KITTITAS COUNTY FIRE DISTRICT 2
2020 Vantage Hwy
Ellensburg WA 98926
933-7232 (office) ☎ 933-7240 (fax)
kcfire2@elltel.net

July 25, 2006

I have reviewed the Application for the DCCDLC LLC Short Plat SP-06-64. I provide review of proposed development and construction for Kittitas County Fire District 2. The Fire District has no code enforcement authority so my input is, for the most part, informational only.

DCCDLC SHORT PLAT

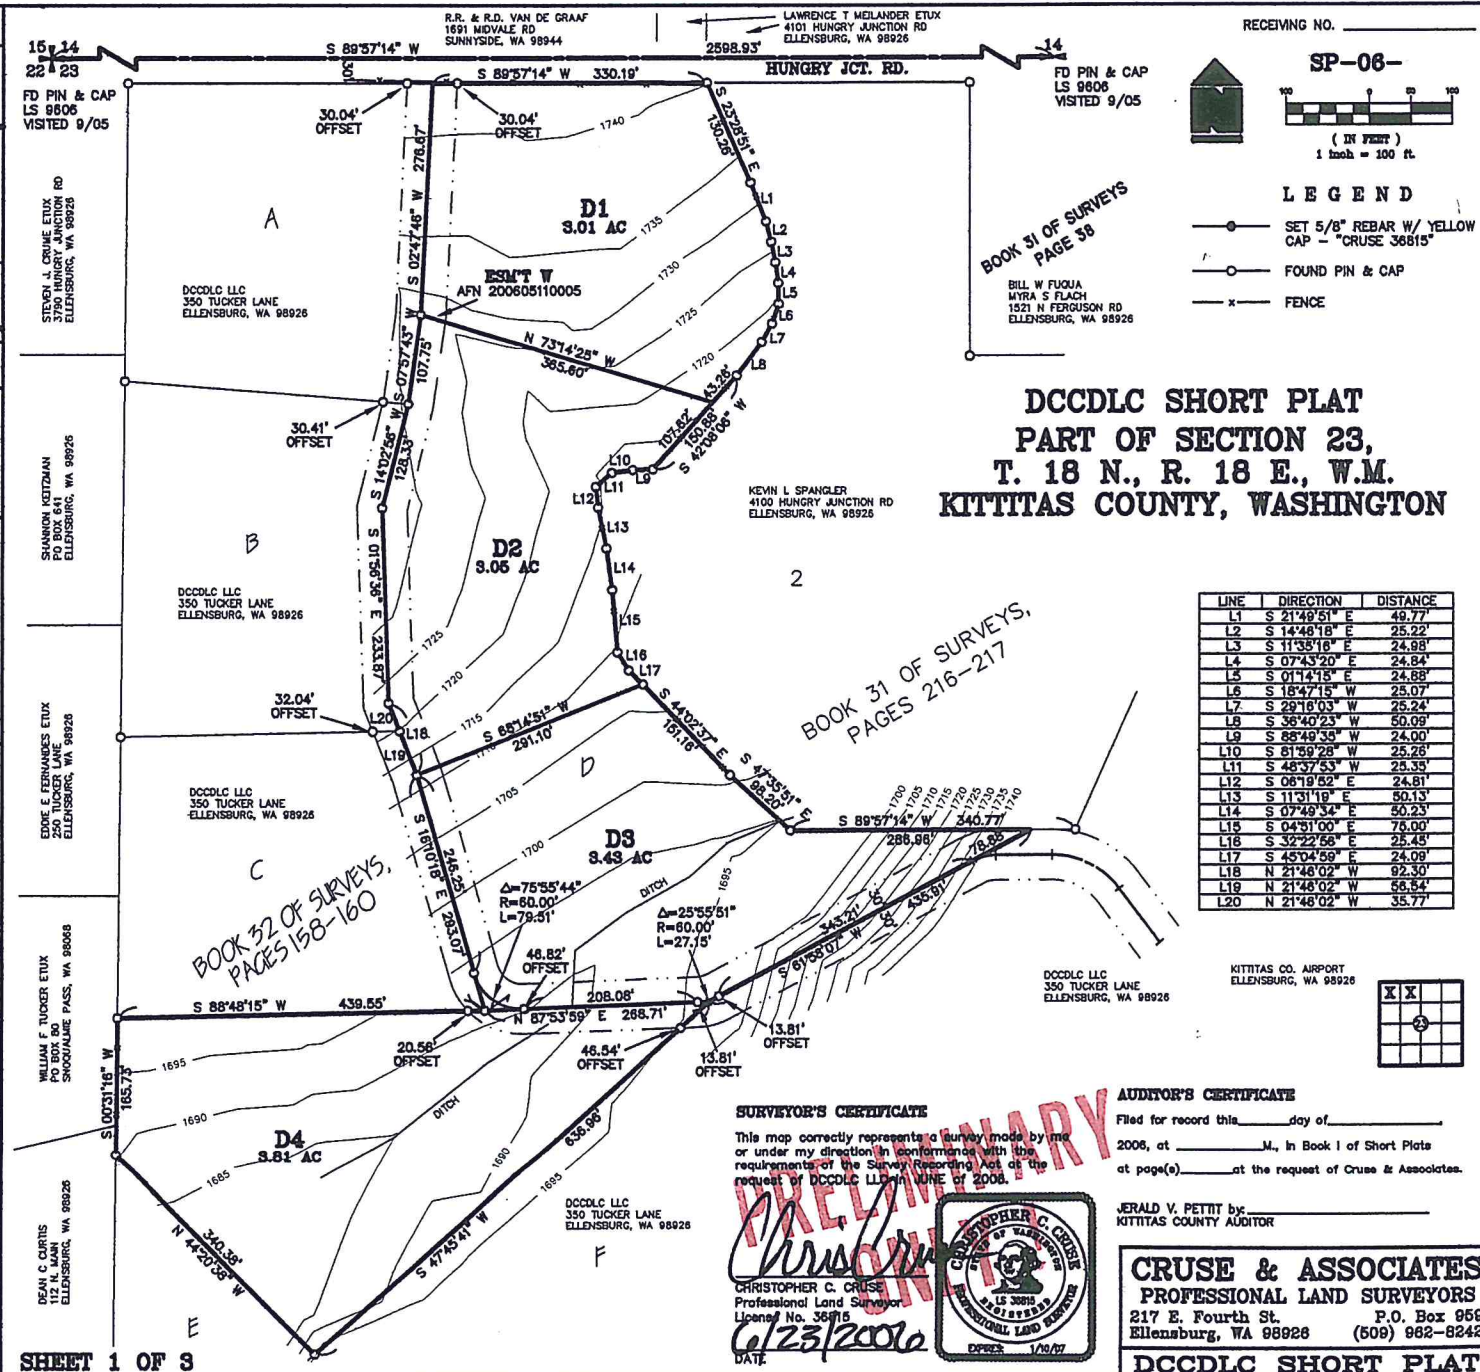
1. The map on the back page does not clearly indicate that the fire department access road will be 20' wide and capable of support 75,000 lbs with an all-weather surface. It is also not clear that the turnarounds comply with Appendix D of the 2003 International Fire Code.
2. The addresses need to be clearly visible from both directions at the county road for all properties.
3. If the property is gated, the fire department will require an access padlock be provided by the owner/developer. Padlocks run approximately 80.00 and an access box runs 150.00.
